17 January 2019
Ref: 56/2018

**RE: Amended Response to Agency Submissions Tweed Valley Hospital (SSD 9575)
Land Use Conflict Risk Assessment Mixed Agricultural Use on Proposed Tweed
Valley Hospital Lot 11 DP 1246853 Cudgen Road, Cudgen**

Tim Fitzroy & Associates (TFA) has been requested by TSA Management to respond to issues raised by the Department of Industry (DoI) and Tweed Shire Council (TSC) with regard to the *Land Use Conflict Risk Assessment Mixed Agricultural Use on Proposed Tweed Valley Hospital Lot 11 DP 1246853 Cudgen Road, Cudgen* (TFA Ref; 56/2018, 18 October 2018).

## TREE REMOVAL AND PRESERVATION PLAN

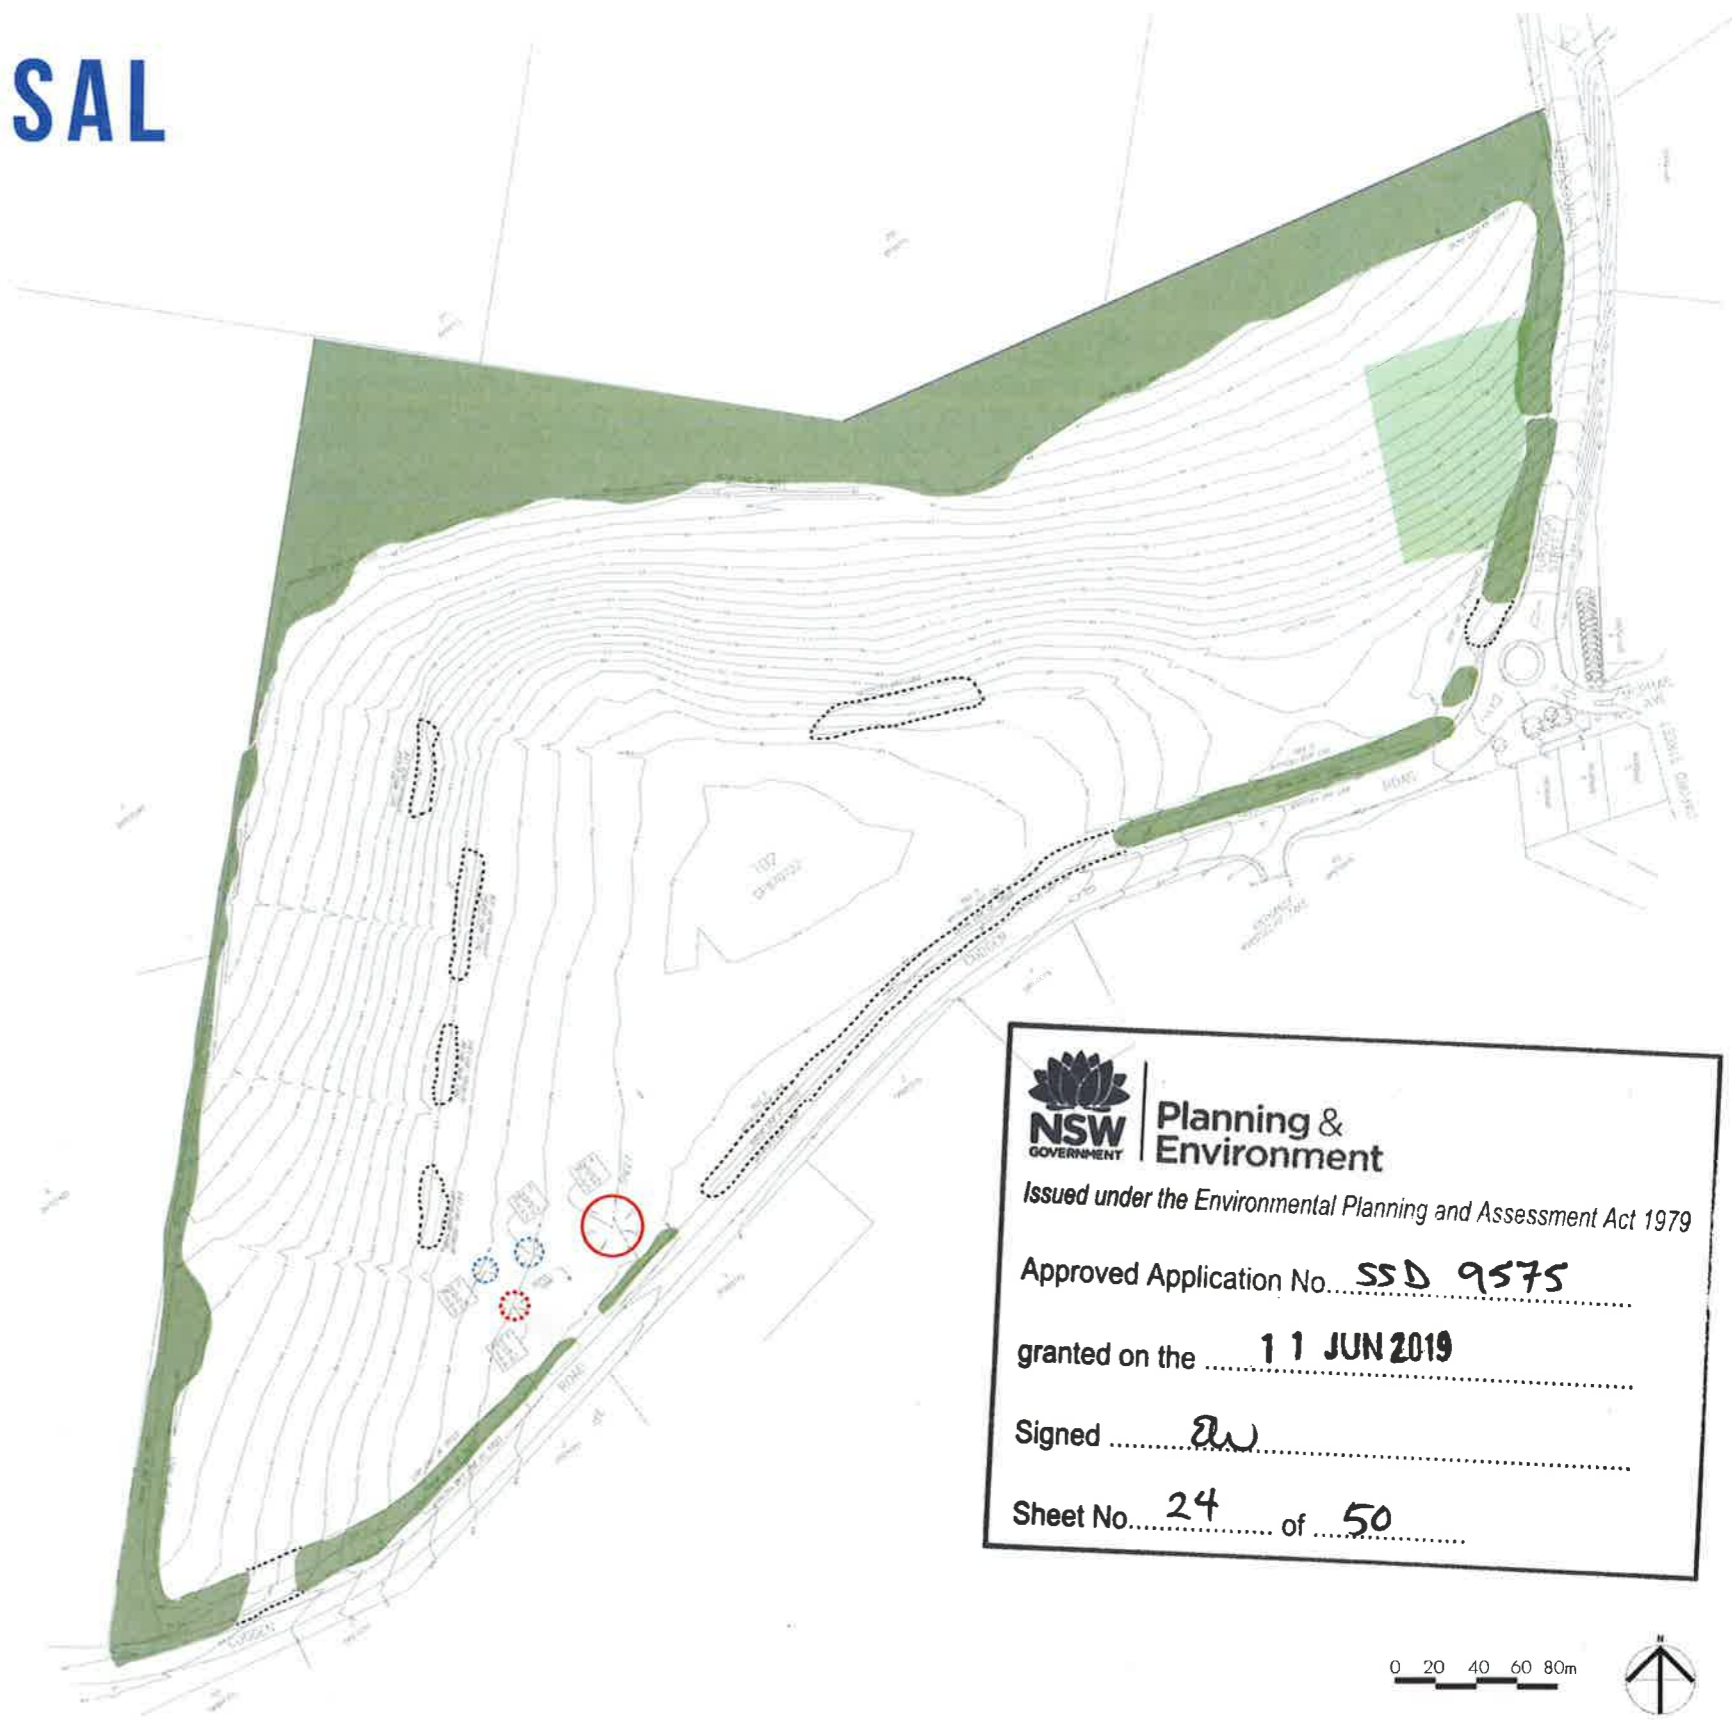
Department of DPI Agriculture supports the development of well vegetated buffers on the western, southwestern and southern boundaries of the hospital. These buffers are to be maintained through the life of the hospital in an effort to minimise conflicts arising from the hospital and its users around standard agricultural practices. The proposed buffer width of 10m on the western and south-western boundary is considered insufficient to prevent land use conflict risk should intensification of agricultural production occur on the adjoining land.

DPI Agriculture requests the hospital design factor in possible changes in land use (intensification of use) on the block of land on the western boundary of the hospital site. The consultants in their various reports only consider how it has been used in the past, not how it could be used in the future with a change in ownership or enterprise.

The proposed vegetated buffers have been developed following an assessment of the specific risk and consequences of conflicts between the proposed Tweed Valley Hospital commercial development and adjoining agricultural uses. Despite there being no existing agricultural land use on the adjacent property to west TFA have adopted the *precautionary principle* in proposing a 3.0m high, 10m wide vegetated buffer along the south western/western boundary with the proposed hospital site. The design / siting of the development enables a future increase in the buffer width to the order of 20 to 30m total vegetated buffer width should this be required as a result of intensification of adjoining agricultural production. Refer to attached 'Agricultural Buffer (West Boundary)' plan.

As noted, the neighbouring property to the west is fallow. The proposed development incorporates a 10m wide vegetated buffer along the western and south western boundary coupled with a carpark for 240 cars, a service yard and ambulance bay prior to the Hospital. The development has been designed as such so that any outdoor use areas for staff and patients and visitors are restricted to the northern side of the hospital. The building therefore providing an additional shield to those described above to agricultural activities.

Guidelines including DPI (2007) have been developed to consider appropriate measures to mitigate potential land use conflicts between existing agricultural uses and new residential developments to minimise instances of incompatibility. However, as a precautionary approach, the design / siting of the development enables a future increase in the buffer

width to the order of 20 to 30m total vegetated buffer width should this be required as a result of intensification of adjoining agricultural production. . Refer to attached 'Agricultural Buffer (West Boundary)' plan.
